BICESTERBUG

Submissions On Proposed Planning Application: 21/01224/OUT / 'Experience Quarter'

**25 May 2021
Version 3.1**

job title: Bicester Motion  
 Brand Experience Application  
 drawing title: Proposed Access

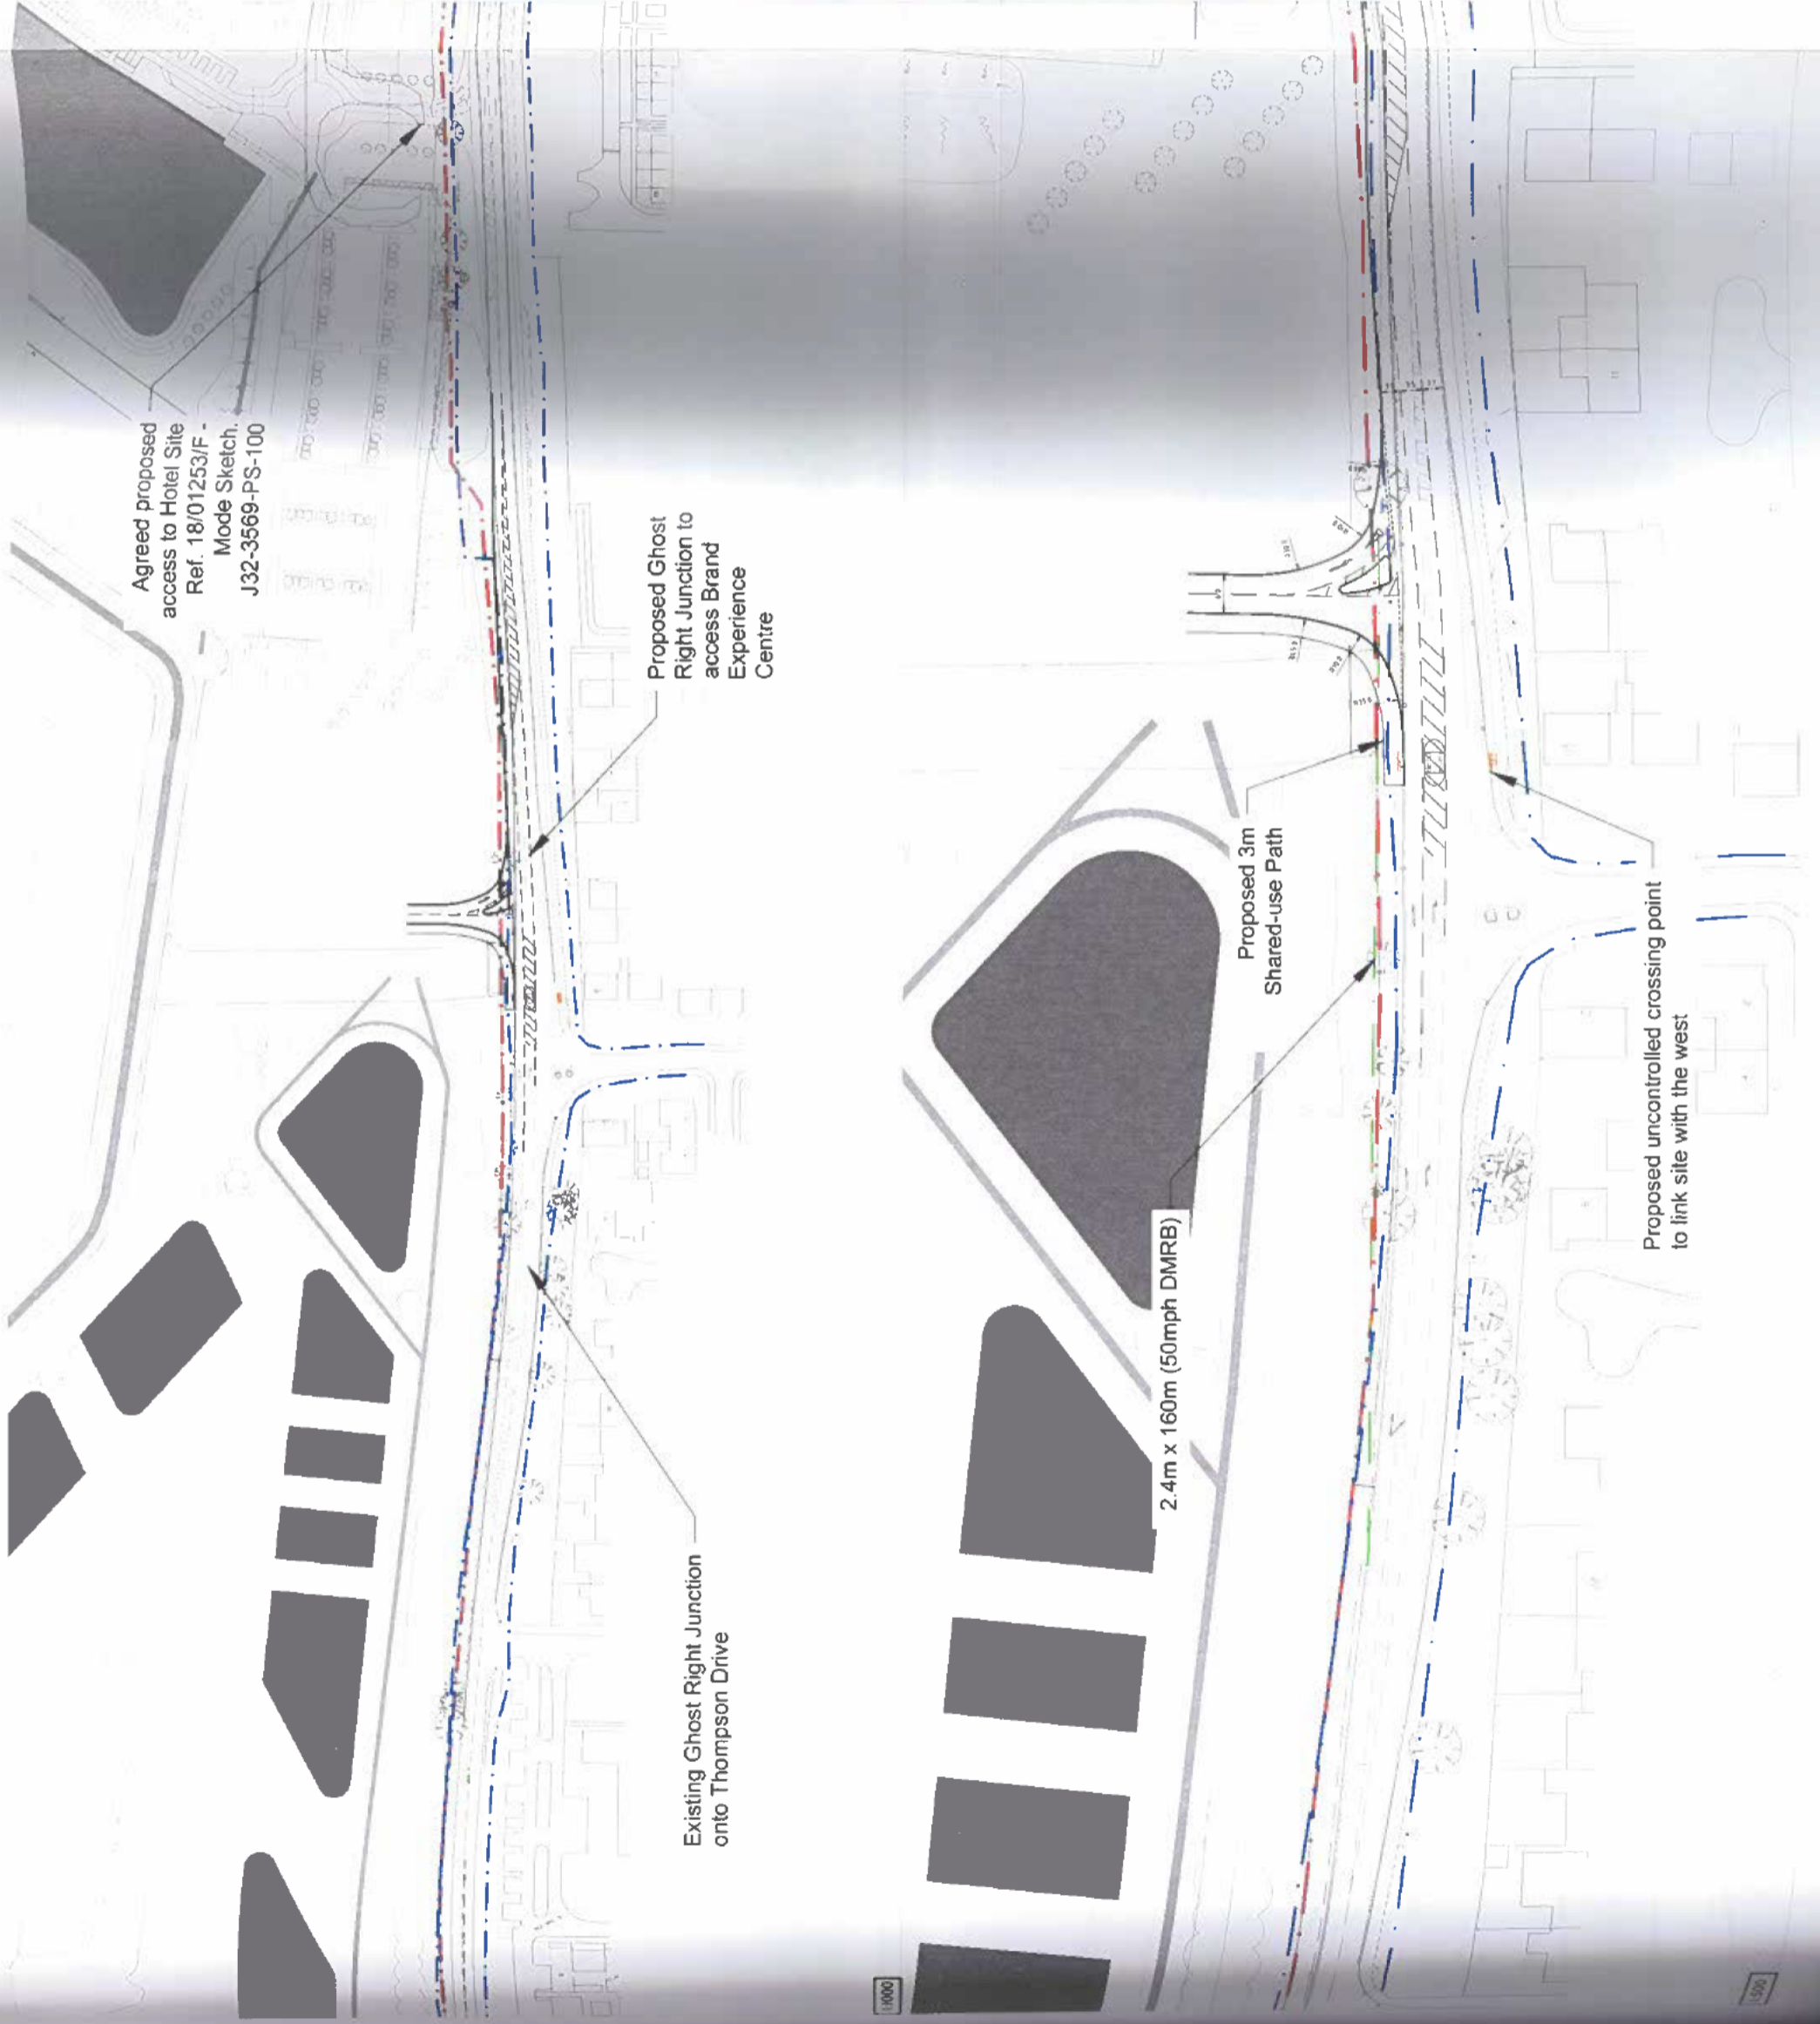
16. The applicant proposes a new uncontrolled crossing over a high-speed road, well to the north of the main entrance to the proposed site and well away from the desire line.
17. Guidance in LTN 1/20 specifies that an uncontrolled crossing over a 50mph high-speed road would be 'suitable for few people and will exclude most potential users and / or have safety concerns'. The recommended solution here would be grade separation or a signal-controlled crossing (DfT 2020, Table 10-2).

18. Furthermore, pedestrian and cycle crossings should not be situated at a distance from desire lines as this falls foul of the requirements of directness (DfT 2020, Table 10-1).
19. Given the above, suitable provision would consist of a signal-controlled crossing close to, or ideally opposite, the proposed entrance. Given the applicant's suggestion of a ghost island, a pedestrian and cycle island could be used to facilitate a pedestrian and cycle crossing to the main entrance.

20. The eastern side of the A4421 Buckingham Road North is a key connection between the site, Bicester Town, and the villages from the north such as Stratton Audley. The A4421 Buckingham Road North is a busy high-speed road that is not suitable for pedestrians and would exclude the vast majority of cyclists.
21. The minimum that would be required here would be cycle and pedestrian provision between the Bicester Road and the Bicester ring road along the frontage of the proposed site that complied with the current standards set out above, ie segregated, of acceptable width, with horizontal separation from the carriageway, and with priority over minor roads such as the site entrance.
